CITY OF ALBUQUERQUE

November 03, 2017

RE: **Peak Motion Addition**
Grading and Drainage Plan
Engineer's Stamp Date 10/26/17
Hydrology File: C19D057

C101

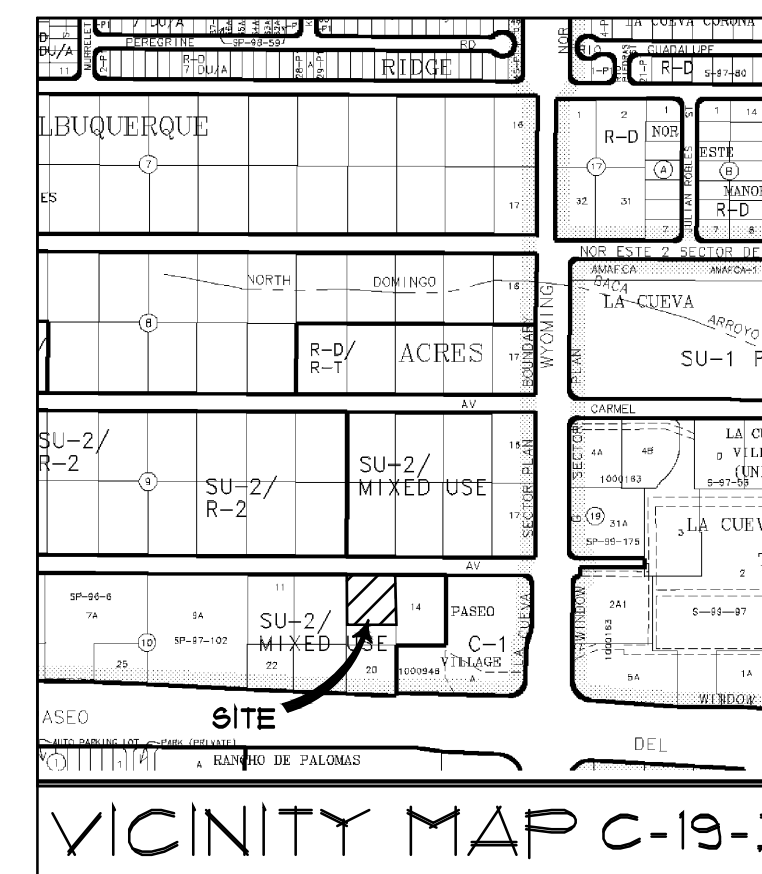
1. This site is located in Precipitation Zone 3, not 4.
2. The Stormwater Quality volume for the additional impervious area needs to be quantified and retained on-site.
